From: Michael Eastham
Sent: 07 June 2018 14:46
To: Planning.Responses
Subject: FW: *EXTERNAL: FW: Response from ADC Drainage to LU/49/18/DOC - Kingley Gate
Attachments: 4485_257E External Works Layout - Mixed Use and Changing.pdf

LU/49/18/Doc Condition 4

Response from ADC Drainage to LU/49/18/DOC - Kingley Gate

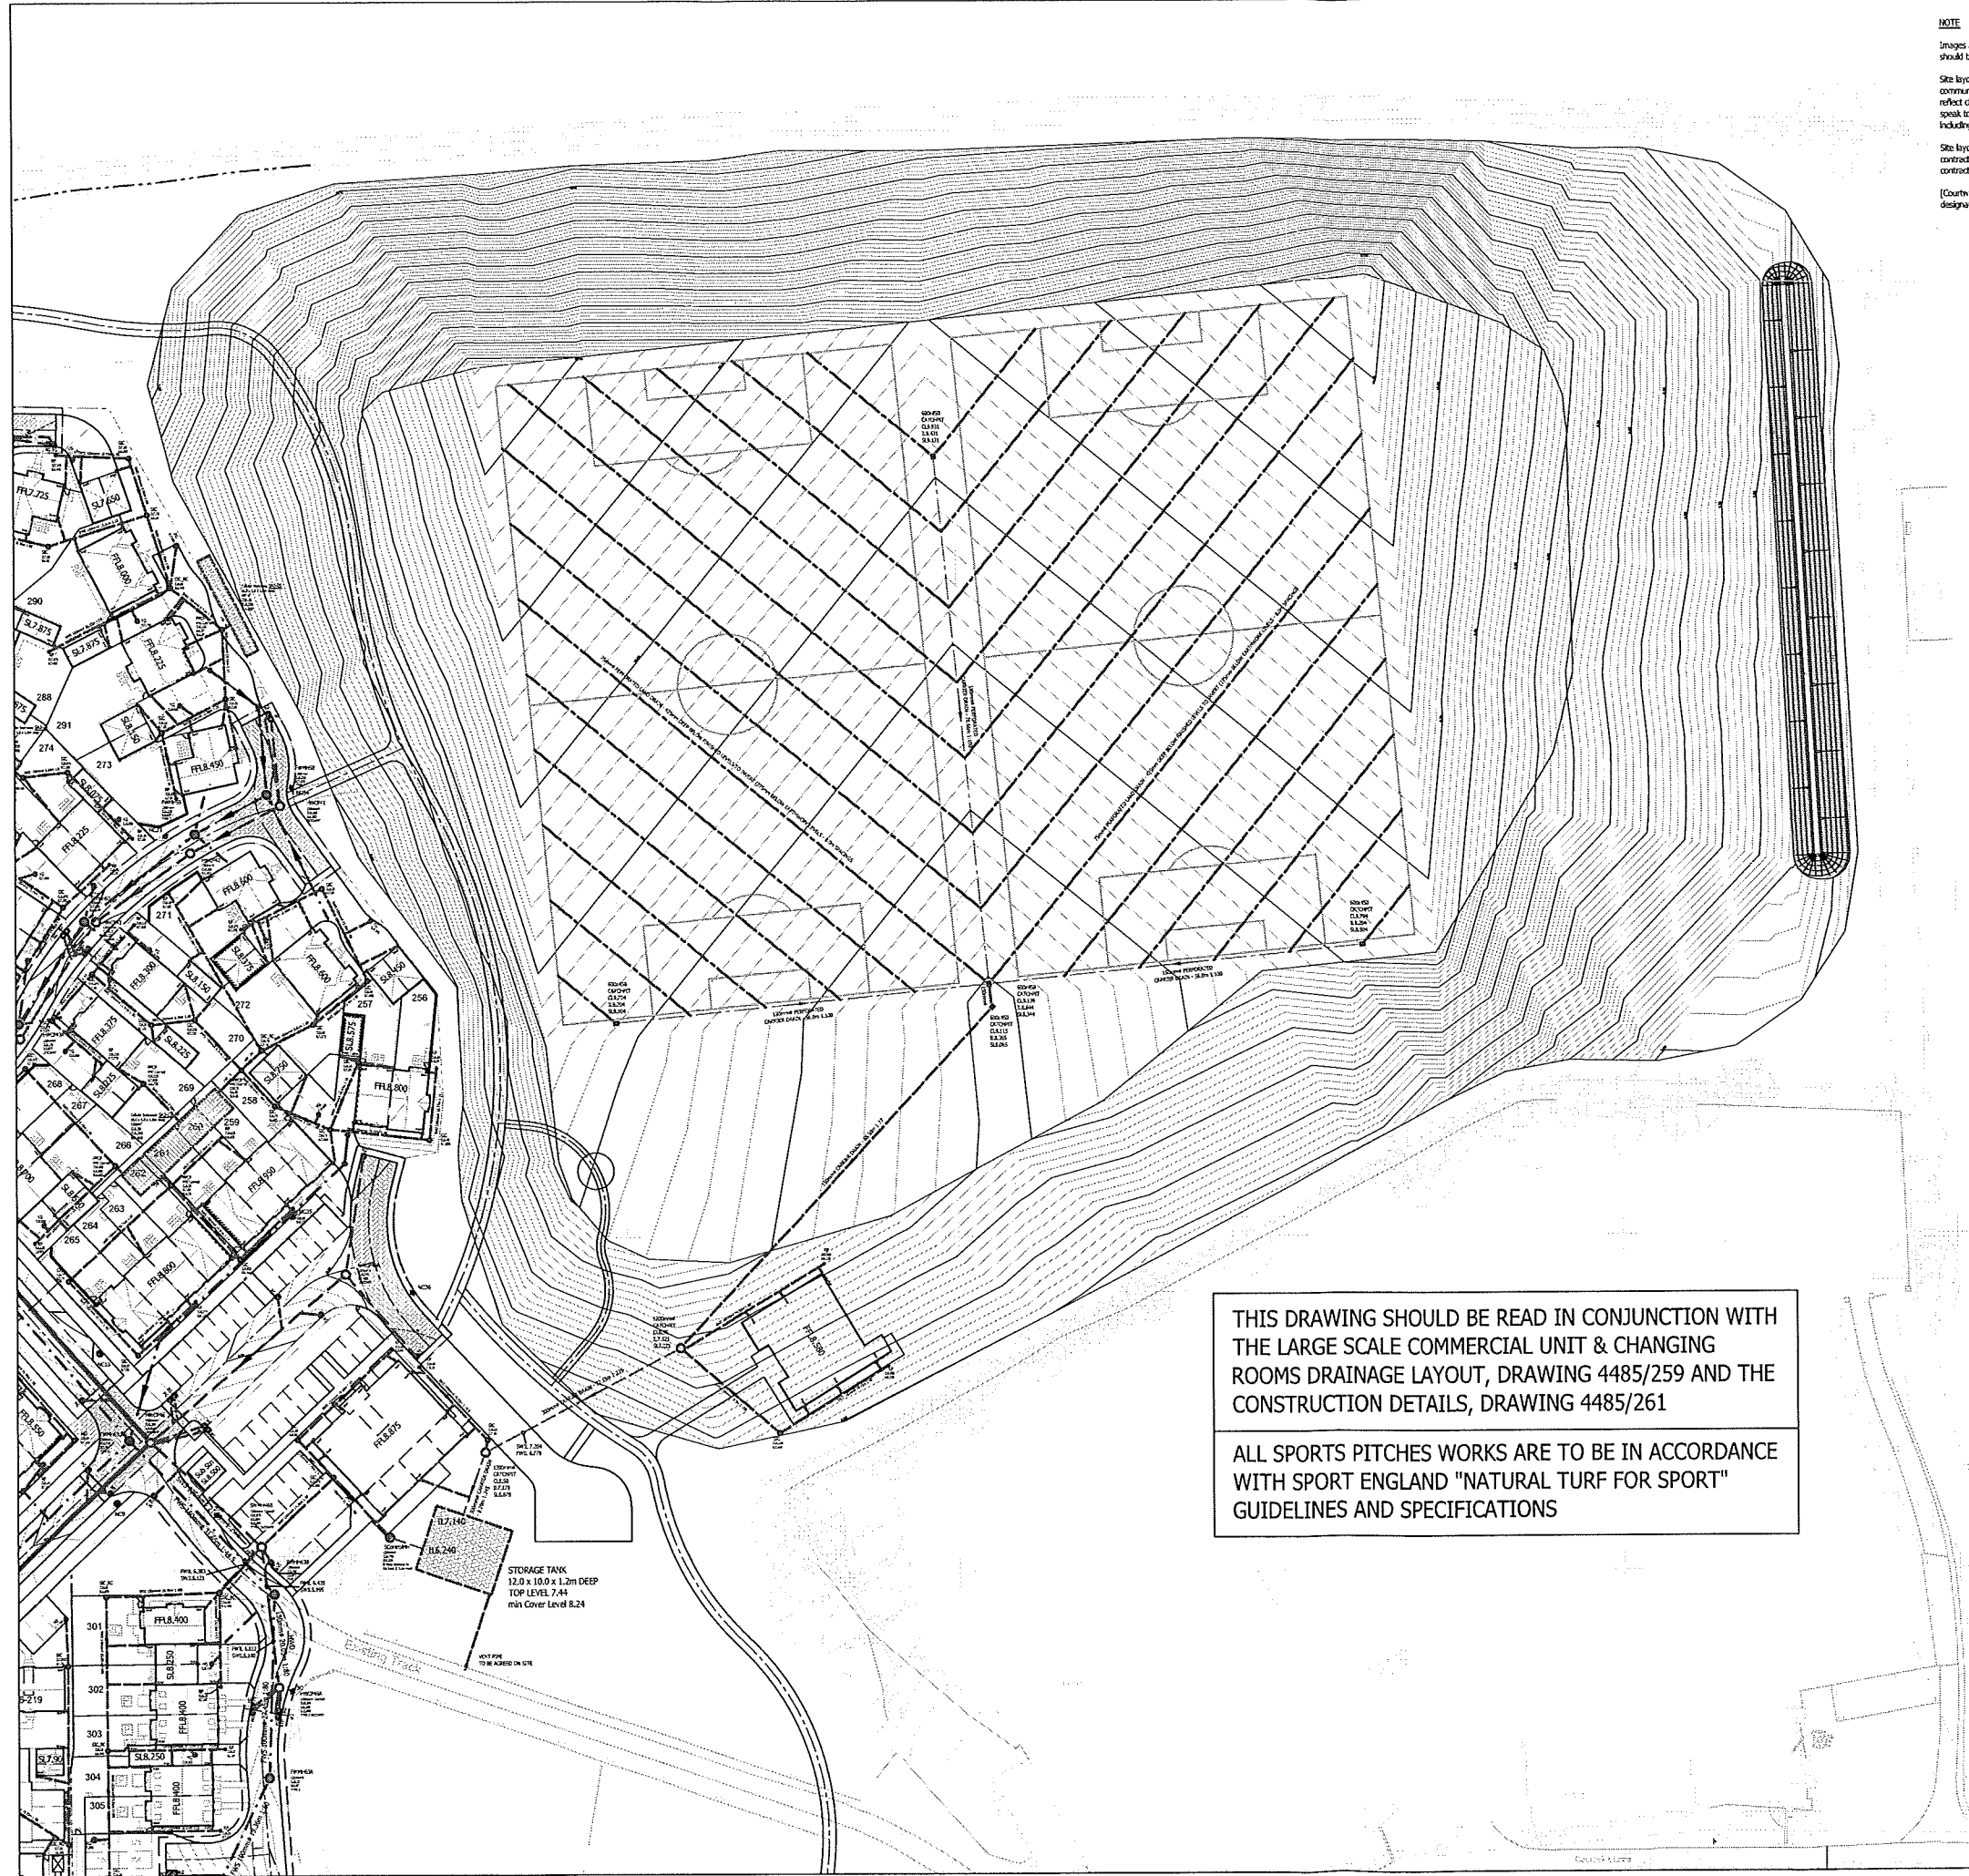
I have reviewed the supplied information. Land drains have been specified directly under the sports pitches. However, there is nothing to control the run off of water down the slopes from the raised pitches, and to prevent it from discharging on to neighbouring land. There is also no method of intercepting the surface water run-off from entering the sports pavilion. Therefore, my previous comments still apply:

Drainage from the site needs to be controlled to ensure no detriment is caused to surrounding land and properties. Currently the plans show no way of controlling run off from the site. We recommend this is reviewed, and drainage is included around the perimeter and that the proposed changing facilities also have drainage around them to ensure that surface water does not flow off of the pitches and through them.

The sports pitches are going to have drainage installed to meet Sports England requirements.
